July 15, 2020

***Legacy Church – Green Mountain Falls: Drainage Revision Memo***

REV: 7/15/20  
 REV: 11/22/19  
 REV: 10/18/19  
**SITE PLAN**  
**SHEET 3 OF 14**

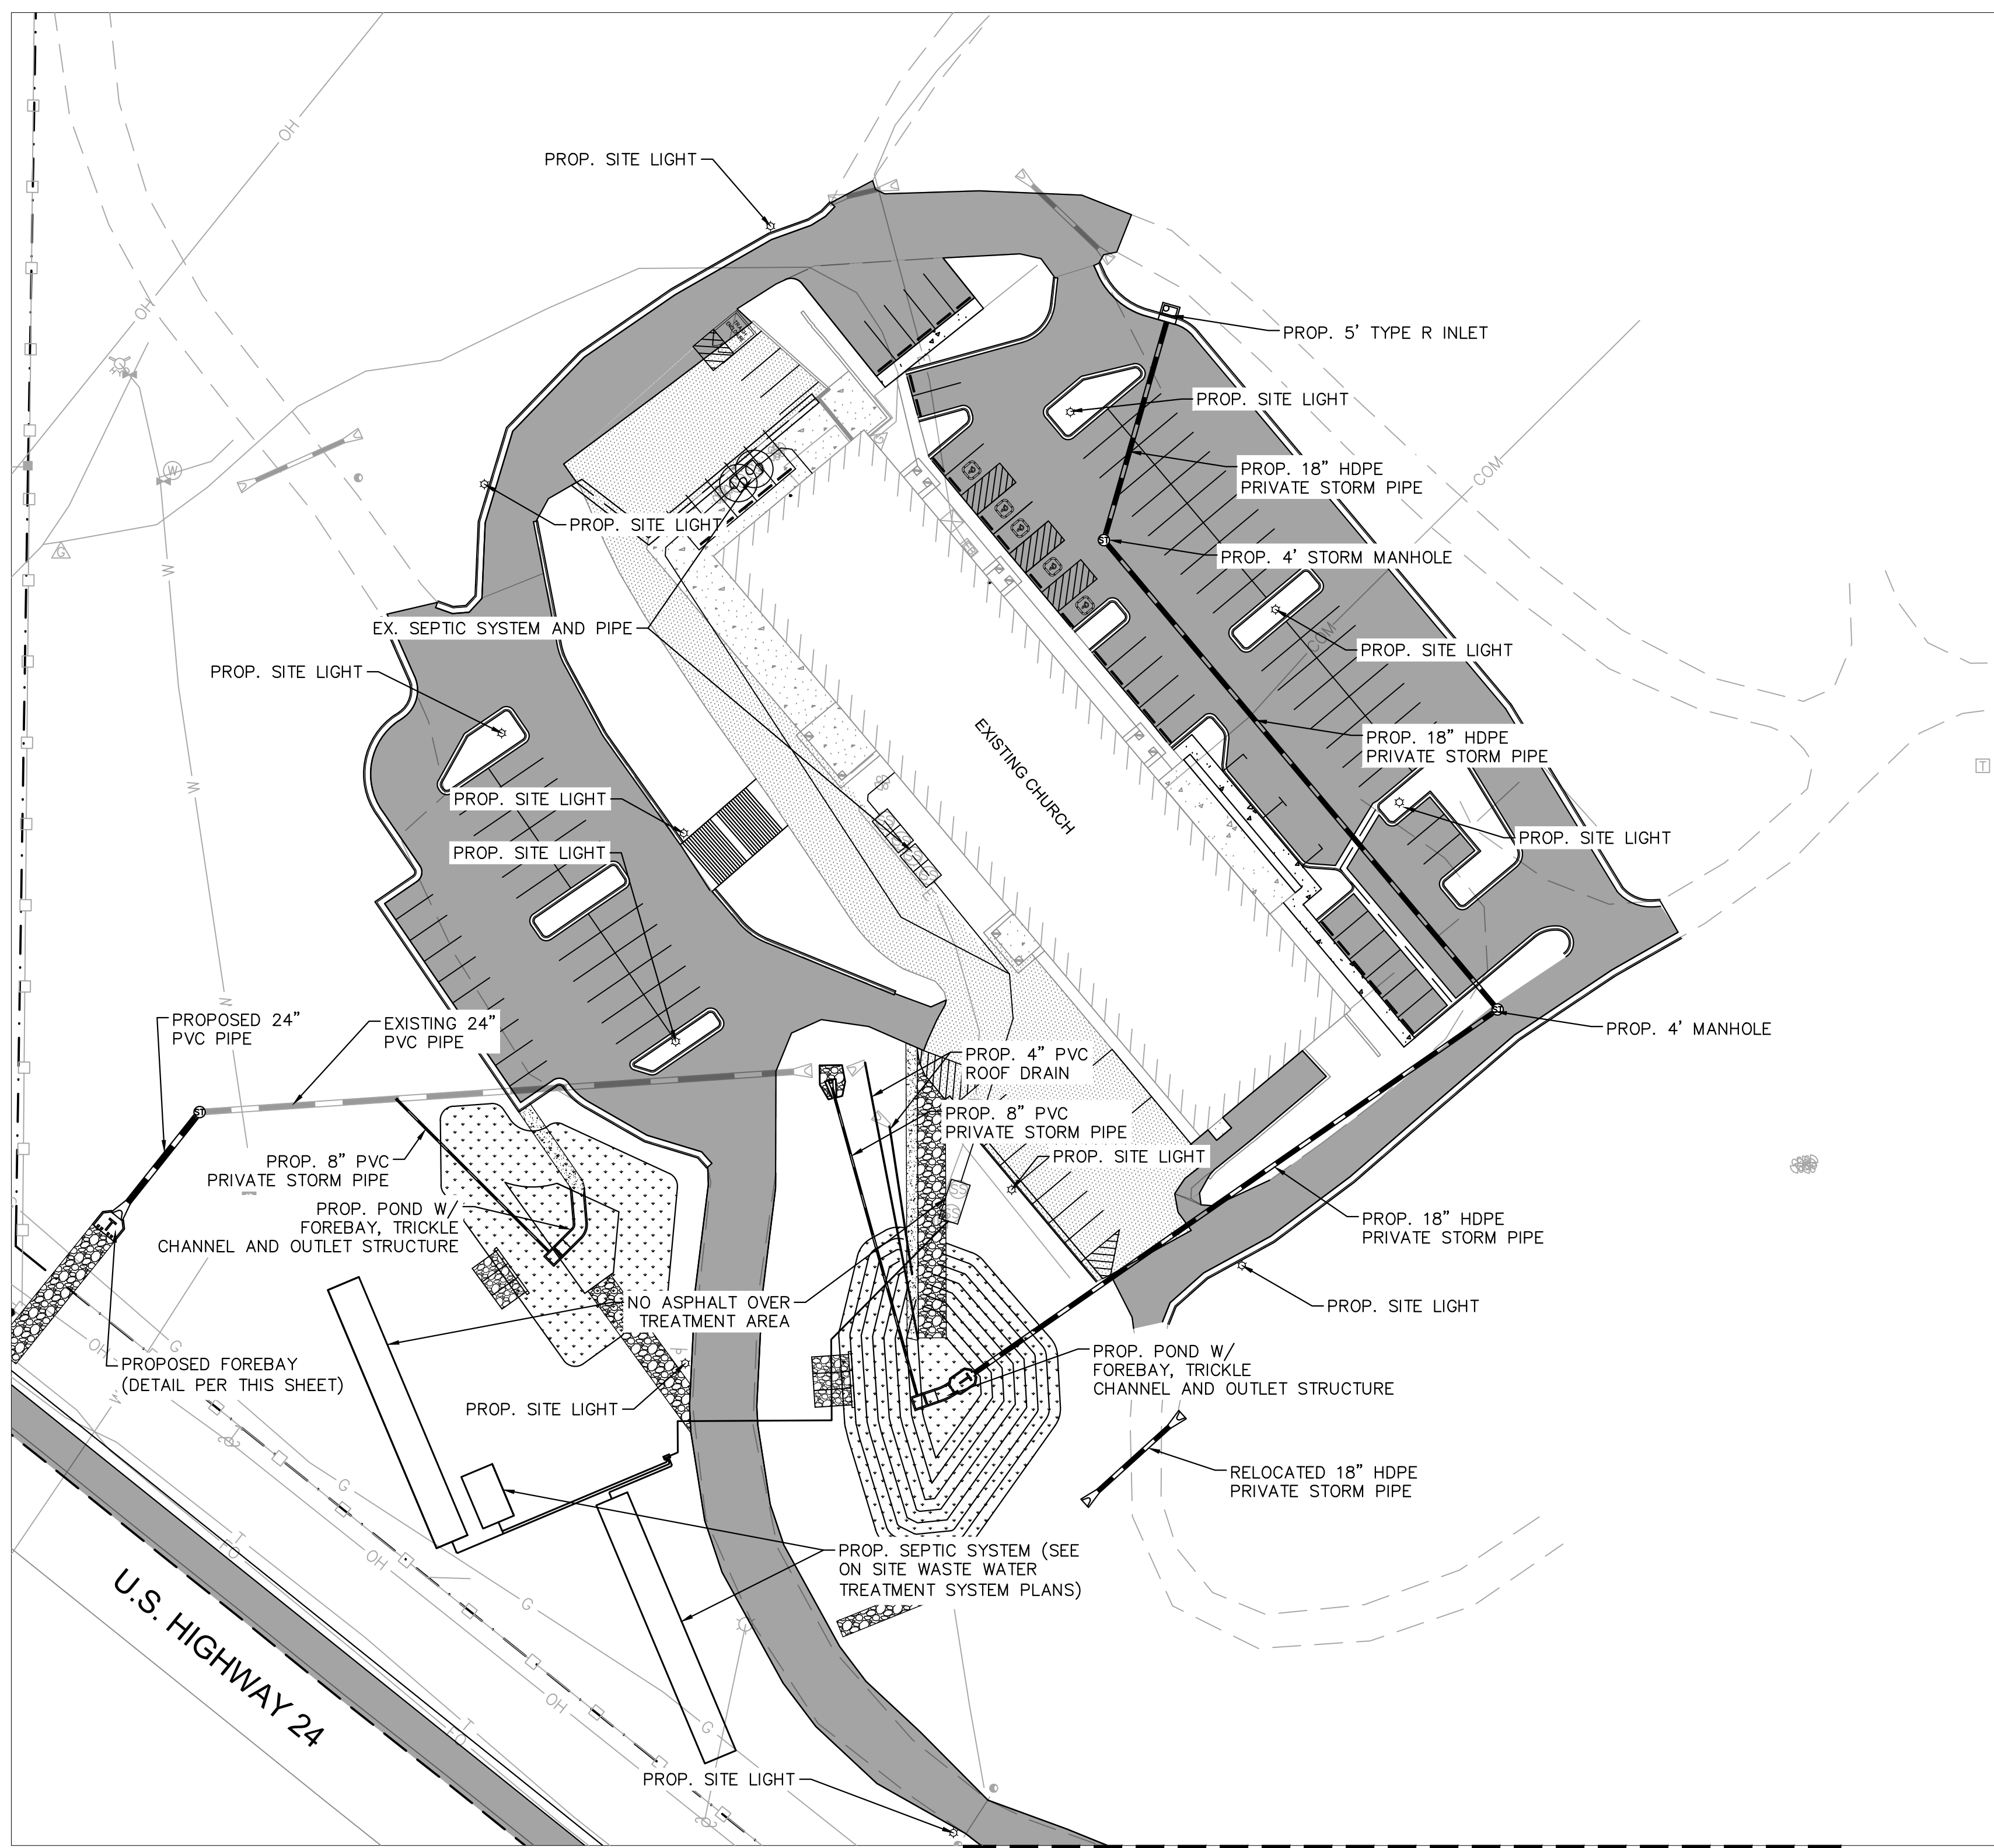
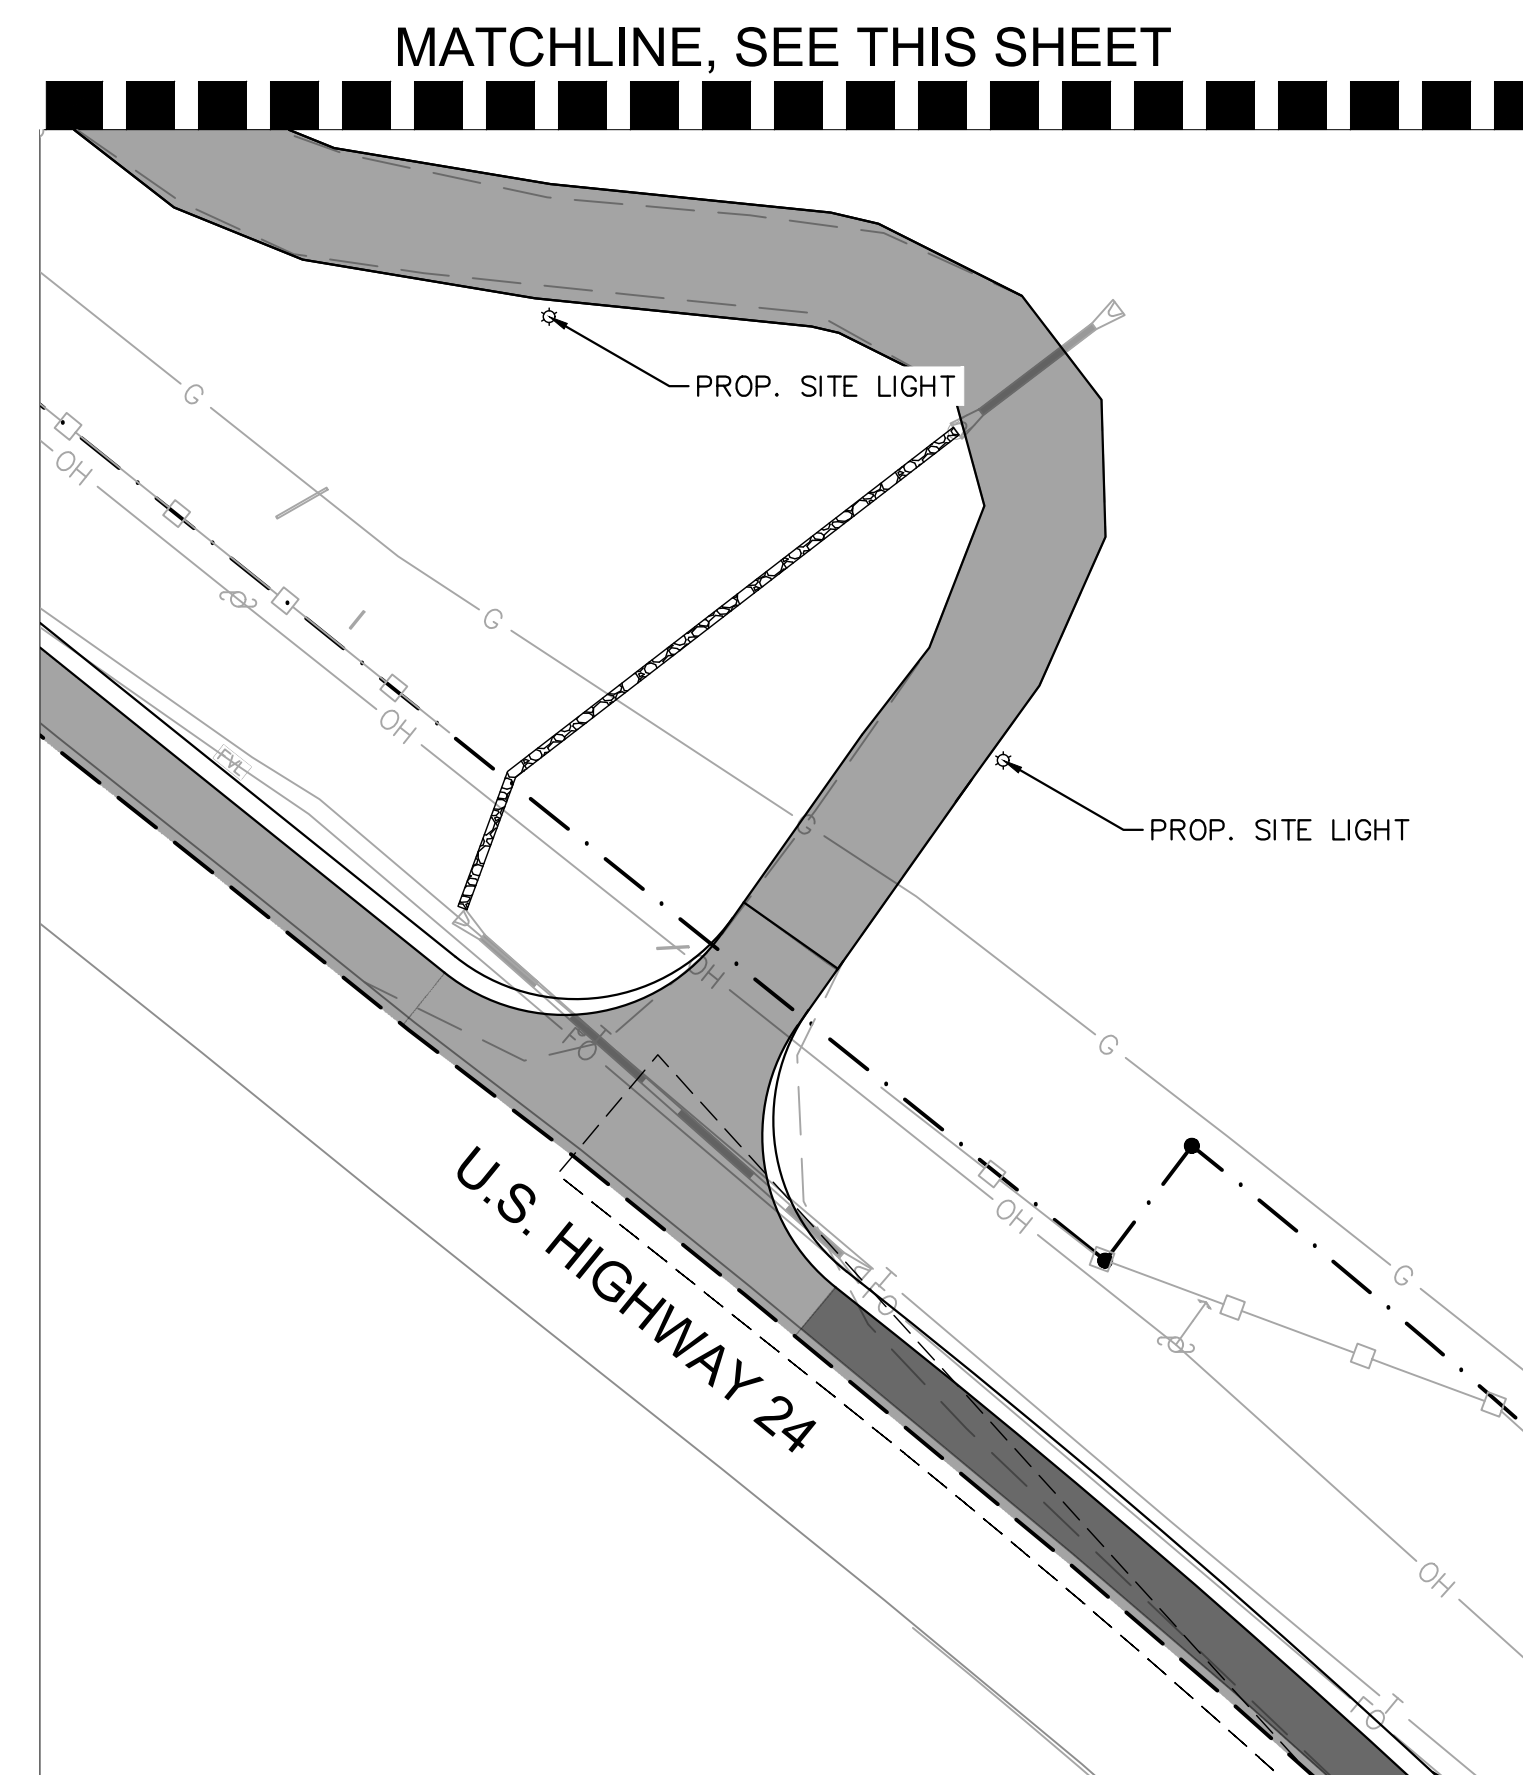
1. The layout of the curb/gutter in a section near the rear of the building has been revised to account for the removal of an existing ground mounted HVAC system. From this change, the net impervious area change was around 20 SF, which would not significantly impact the detention pond system.

2. With the addition of the RTU pad along the northeast side of the building, the sidewalk shifted as well as some parking spaces and islands. After this shift, the proposed site plan includes 117 spots (with 106 as the required minimum). This is sufficient from a code perspective.

3. All ADA stalls have been relocated to a common location along the north side of the building, which will not adversely affect parking counts or detention pond design.

4. Curb and gutter has been added along the drive aisle at the bottom of the proposed staircase on the south side of the Site. This does not adversely affect the drainage patterns for this basin.

5. The proposed trash enclosure on the west of the building has been shifted slightly for constructability purposes. With this shift, a 4' concrete crossspan was added to ensure flows do not enter the building and follow existing drainage patterns. An additional 4' concrete crossspan was also added in the northeast drive aisle for the same reasons. All flows are directed to the approved design points and do not add any additional impervious flows.
